Sent: Tuesday, 20 September 2016 10:58 AM
To: Fiona Gibson
Cc: Myfanwy McNally
Subject: SSD 6387 MOD 4 – 1 Burroway Road – Wentworth Point - Council Submission

**SSD 6387 MOD 4 – 1 Burroway Road – Wentworth Point
Section 96(1A) amendment to approved mixed use development
City of Parramatta Submission**

Project Title
JEWEL RETAIL
1 BURROWAY RD, WENTWORTH POINT, THE WHARF SITE.
SYDNEY OLIMPIC PARK
Drawing Title
CAFE DESIGN

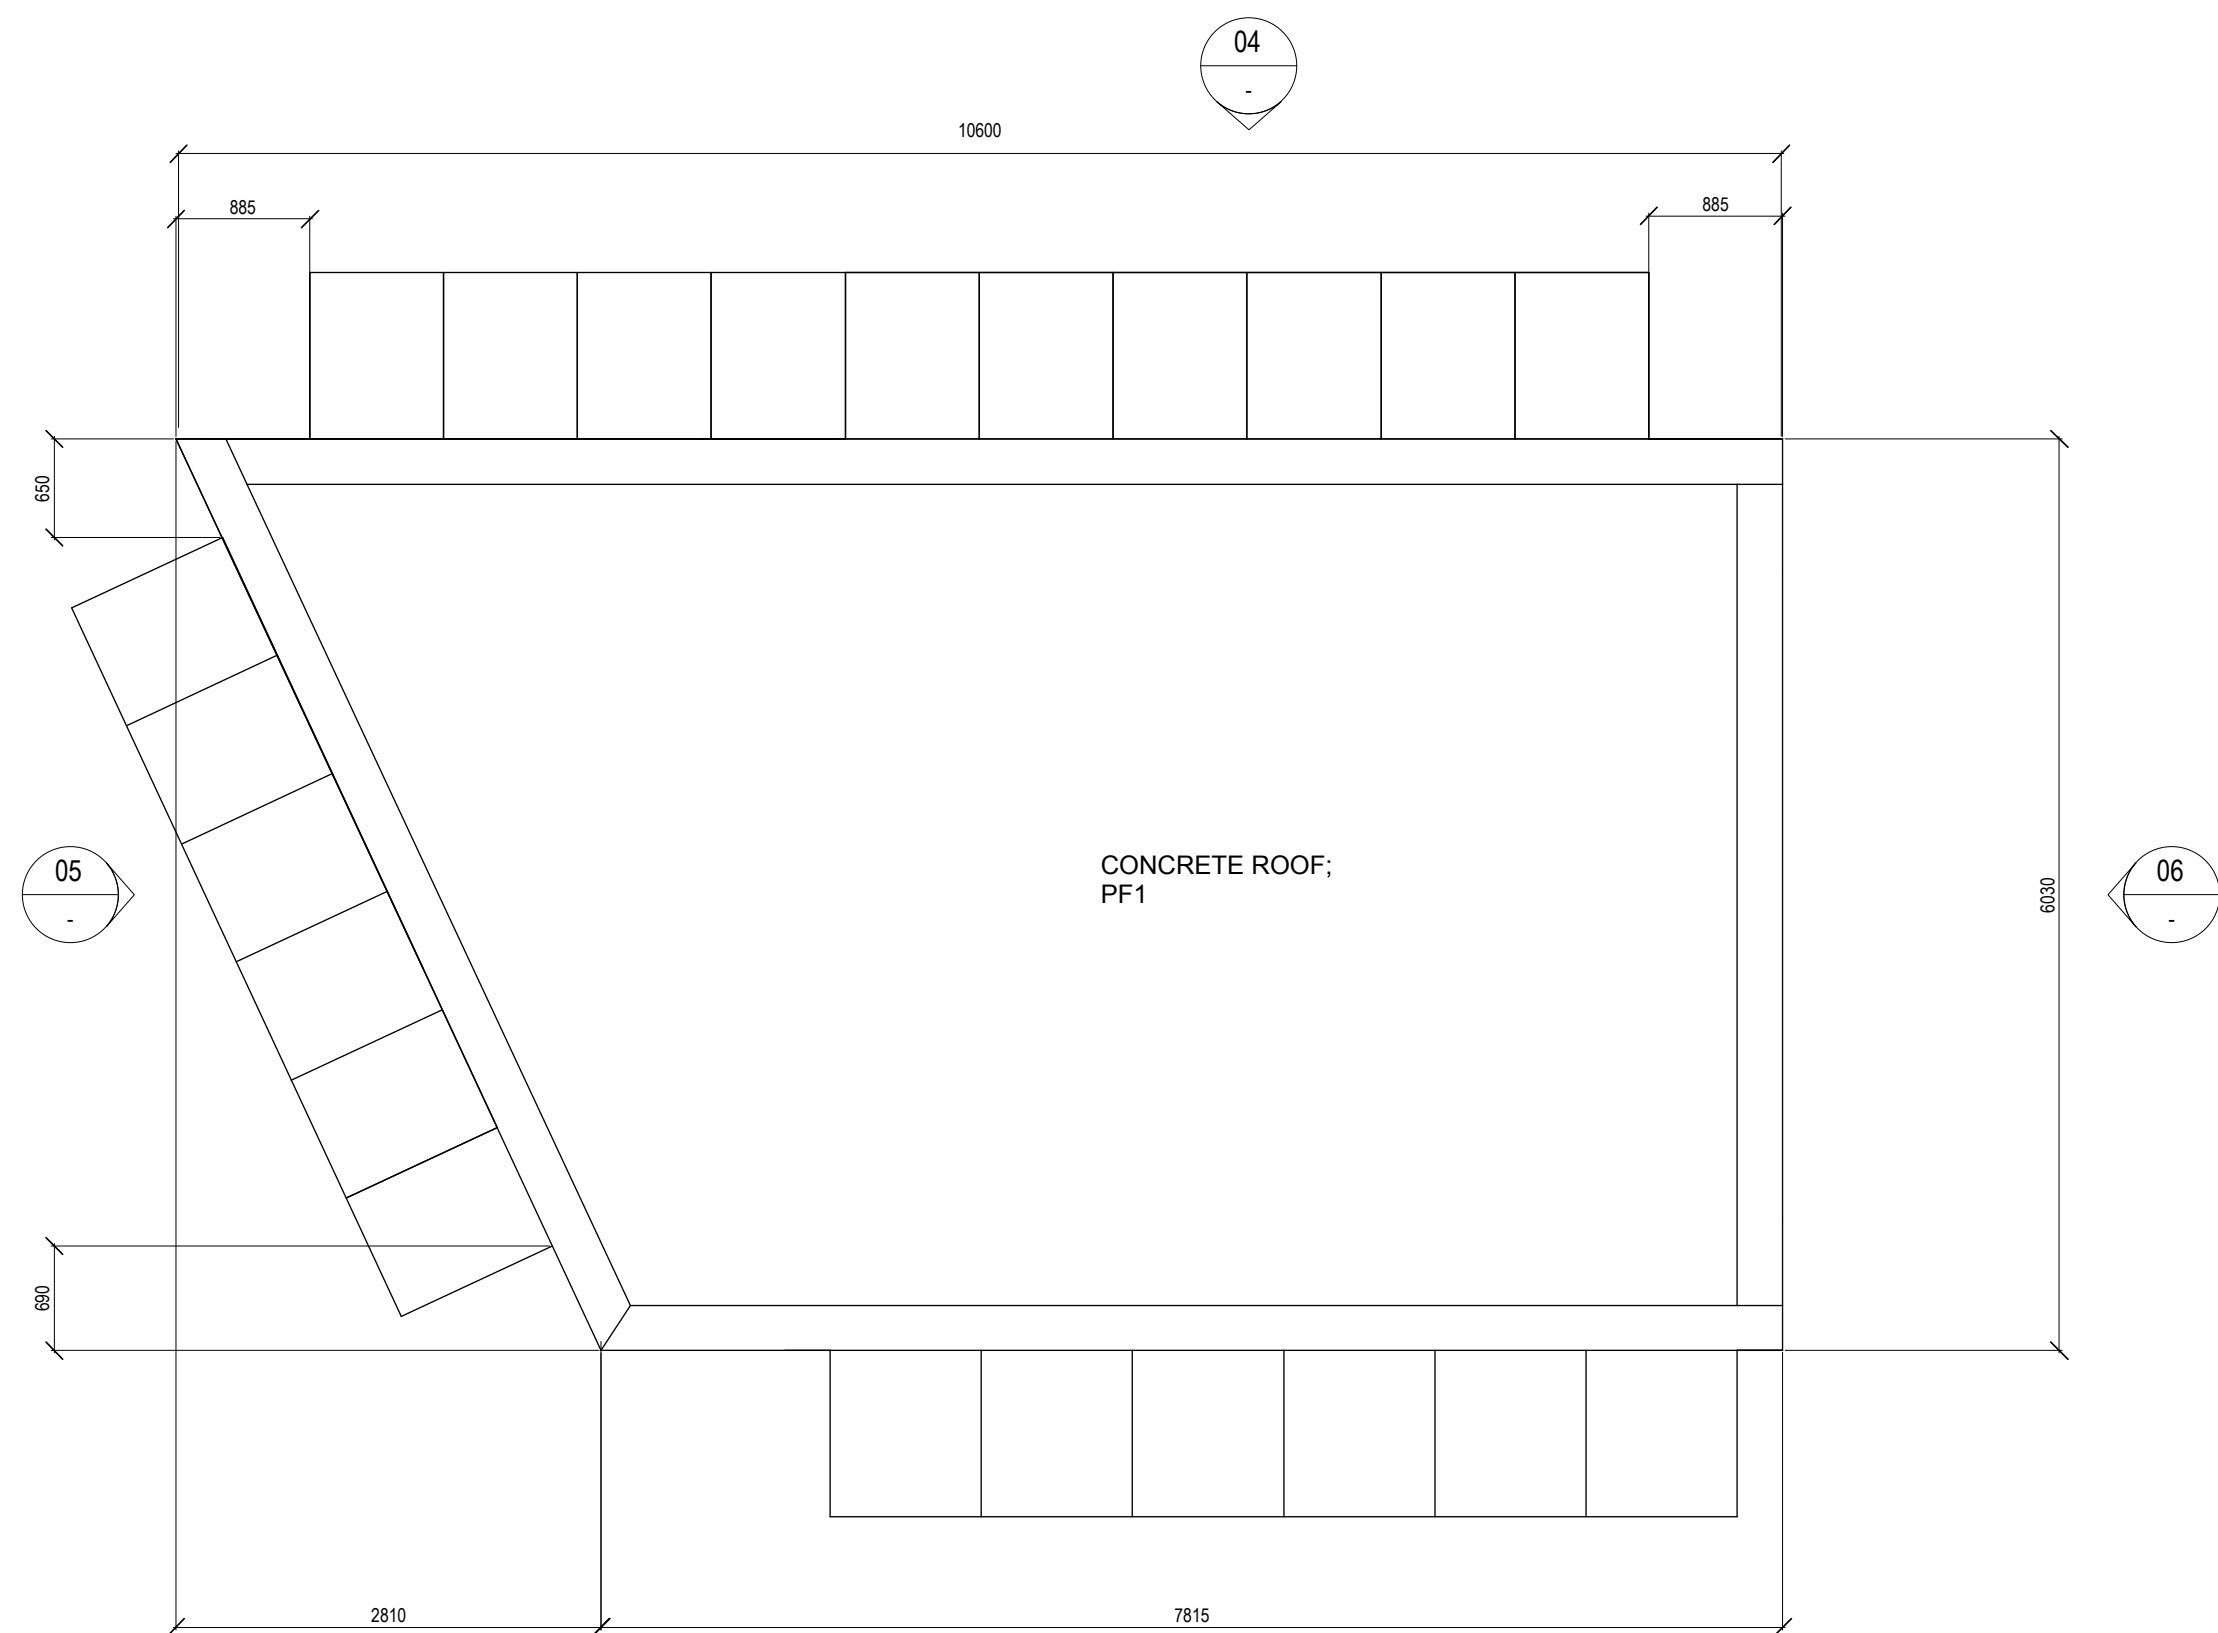
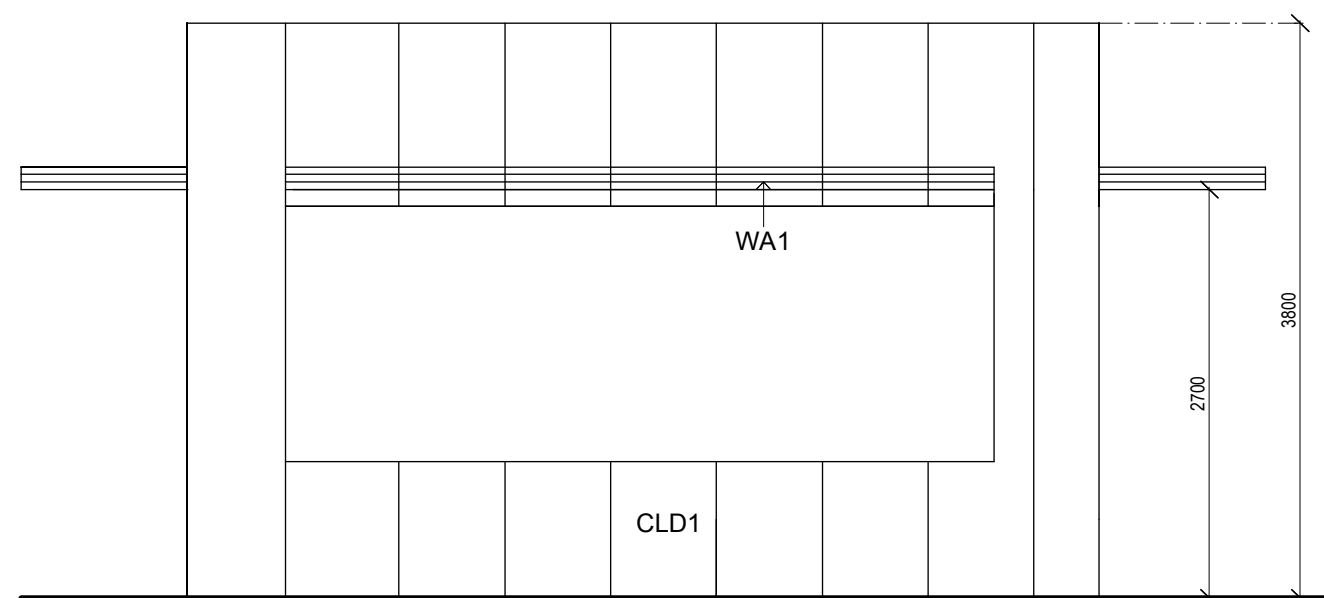
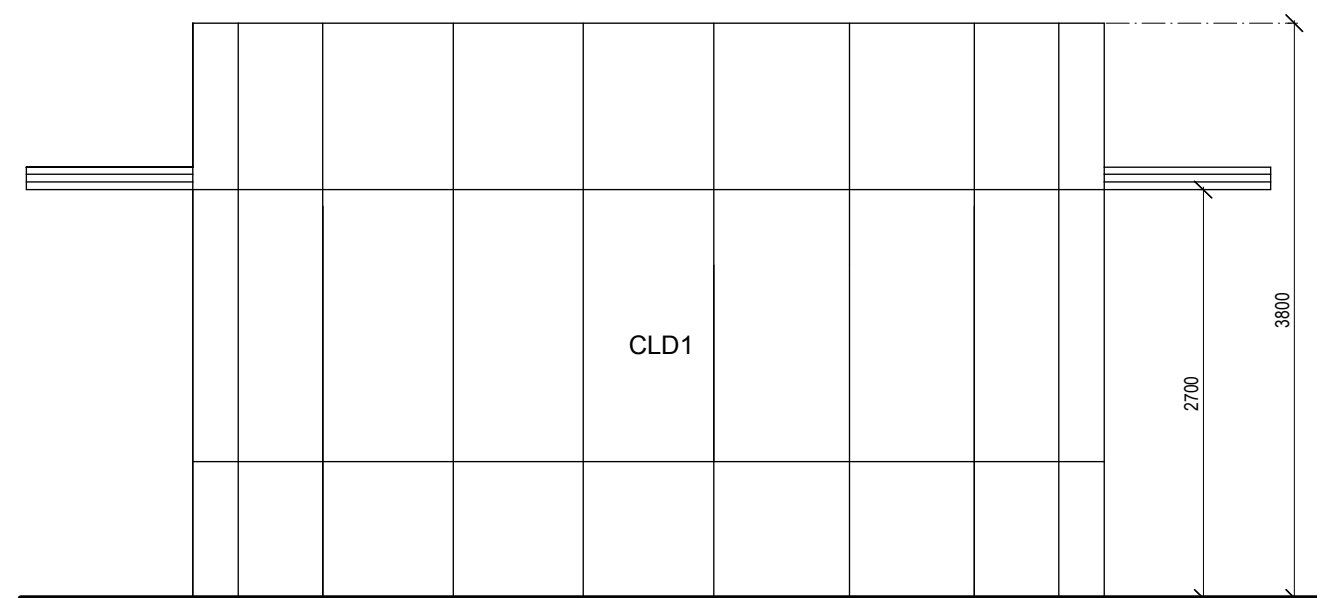
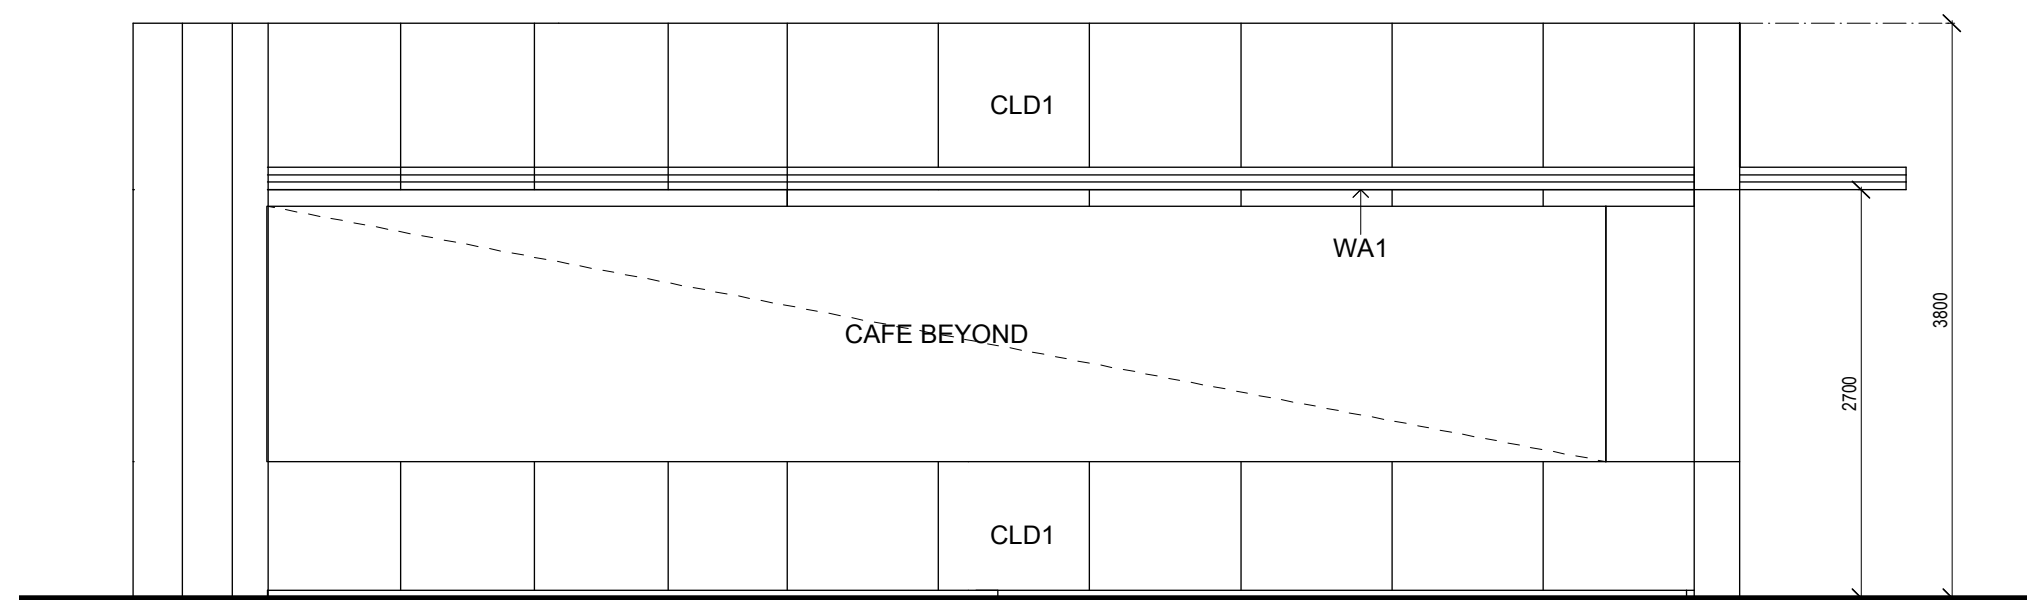
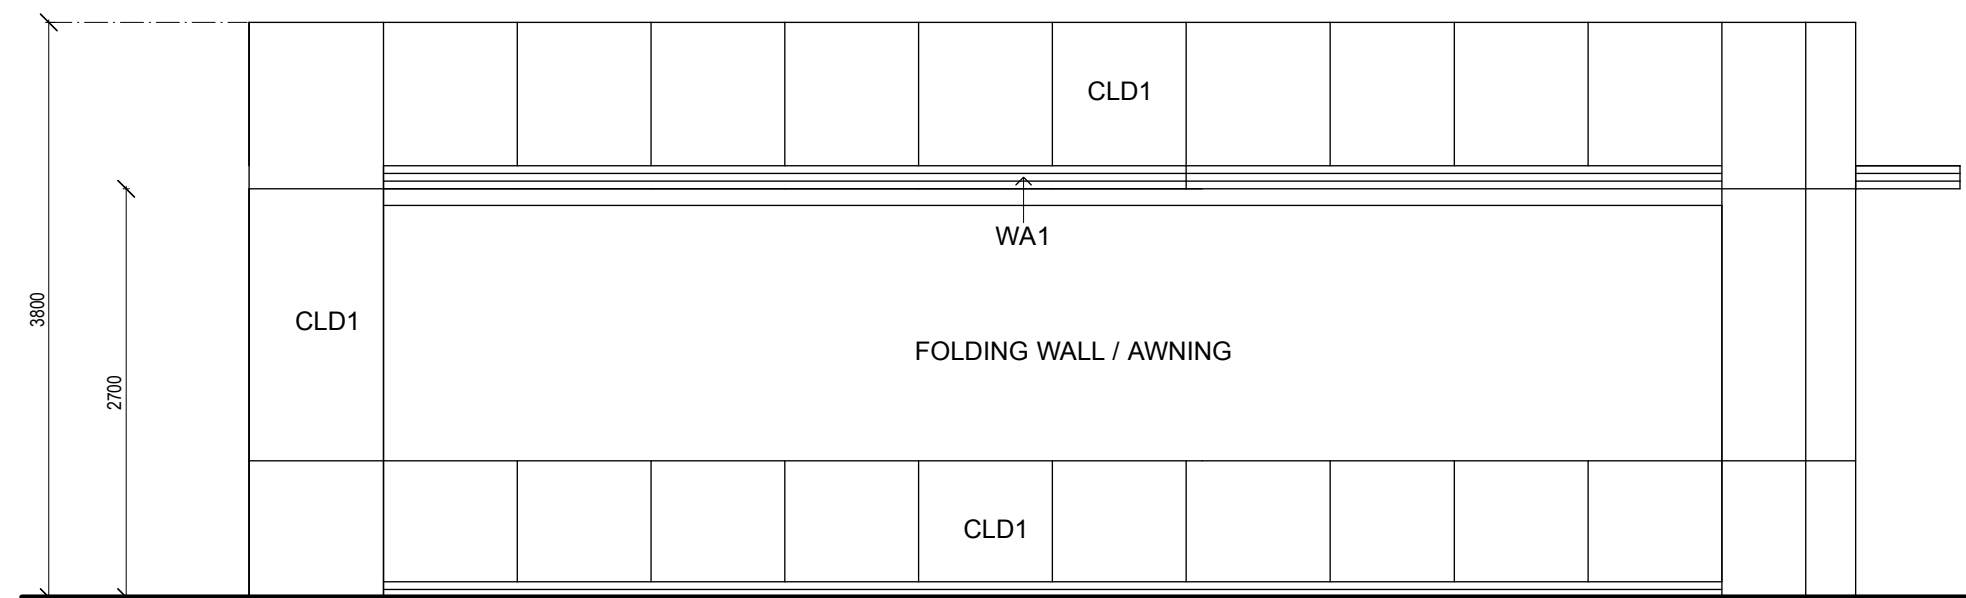
Significant concern is raised with the proposed location of this café. It is a single high structure standing at 3.8m high. It is located at the southern end of the plaza and impedes the visual connection from Burroway Road through the plaza towards the water and the ferry terminal. It also utilises an area which is the gateway to the plaza and impacts upon pedestrian usage (including impeding pedestrian flow). The pedestrian entry to the ferry terminal needs to be clearly defined within the streetscape. It is considered that whilst a café may be an appropriate use within the development site, it should be contained within the ground floor retail component of the development, and not encroach on pedestrian areas. With respect to the above, it is considered that the proposed location of the café does not provide for an appropriate urban design outcome for the public domain.

It is noted that within the Secretary's Environmental Assessment Report for the original application that the SOP Master Plan 2030 applied to the site. It appears that the proposed modification (for the café component) would not comply with the setback and through site link requirements of this master plan. The assessment report also acknowledges the *"proposed pedestrian through-site link ... provides direct and obvious access to the adjacent ferry and bus interchange in accordance with SOP Masterplan"* which appears to justify the non-compliance with setbacks in the original approval. It is therefore considered that the integrity of the Burroway Road setback and provision of the through site link would be further compromised and contrary to the assessment of the original approval. In this regard, it is considered that the location of the café would not allow for the direct and obvious access to the ferry and bus interchange.

Project Title  
**JEWEL RETAIL**  
1 BURROWAY RD. WENTWORTH POINT, THE WHARF SITE.  
SYDNEY OLYMPIC PARK  
Drawing Title  
**ROOF PLAN & SECTION**

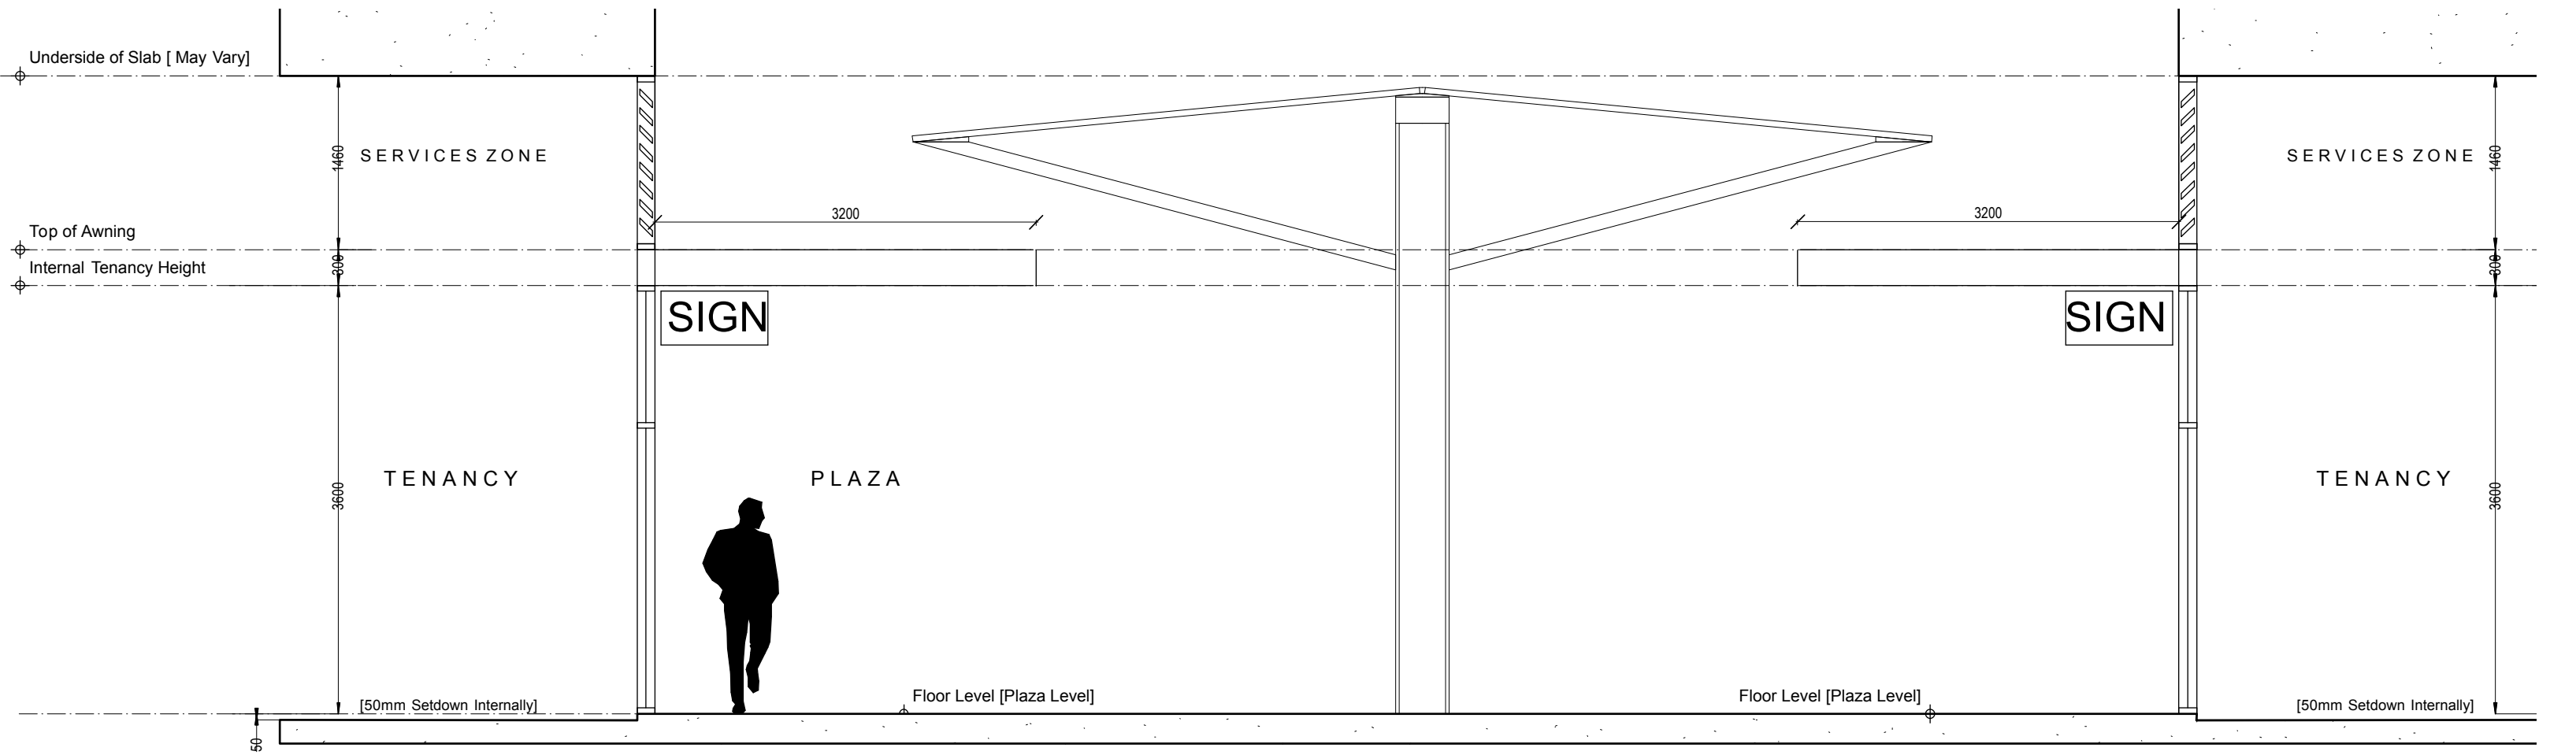
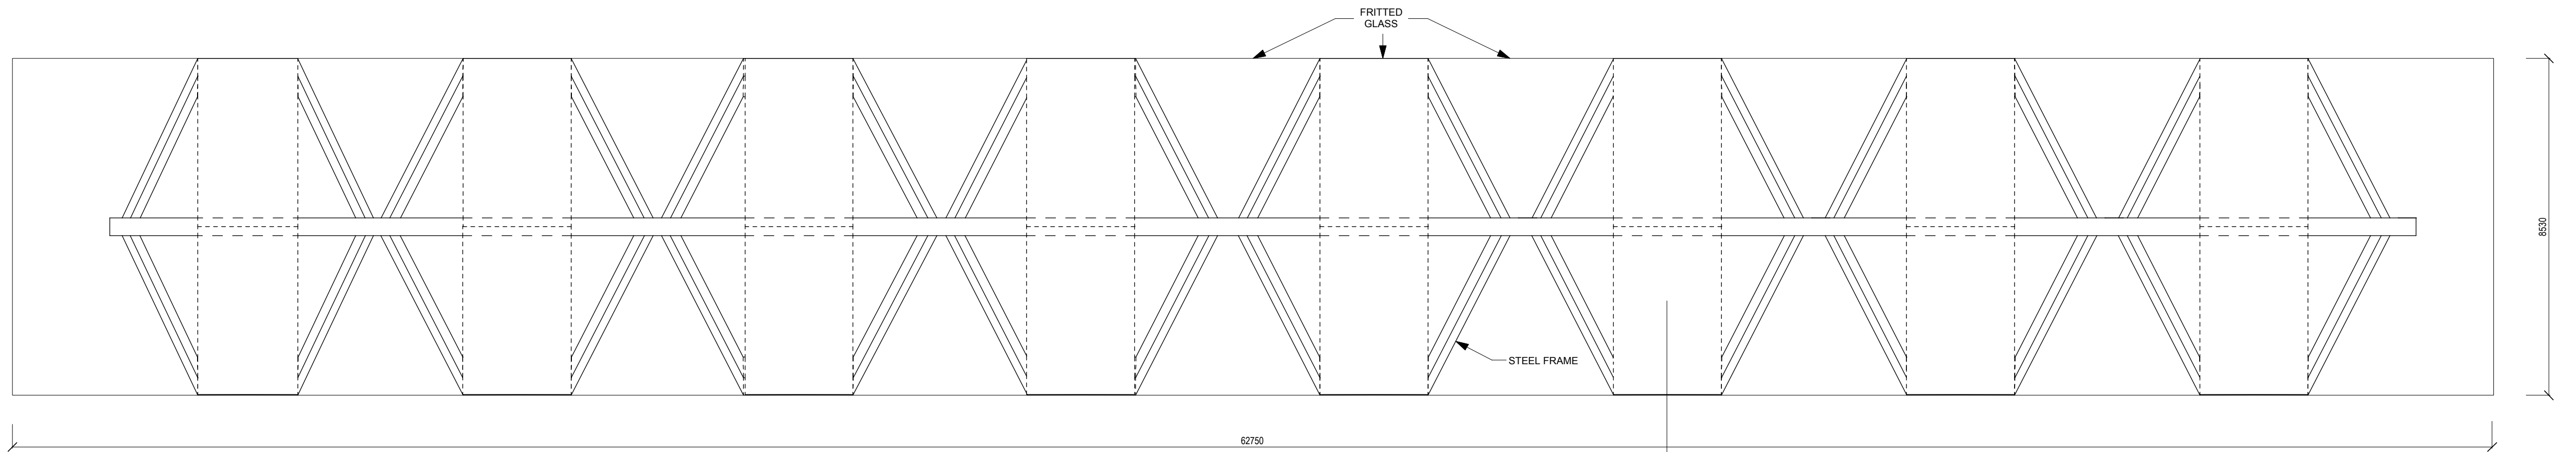
No significant concerns are raised, however it is noted that details of the location of supporting structures have not been provided. In this regard, sufficient pedestrian movement should be maintained throughout the plaza area and appropriate access for people with disabilities will need to be achieved.
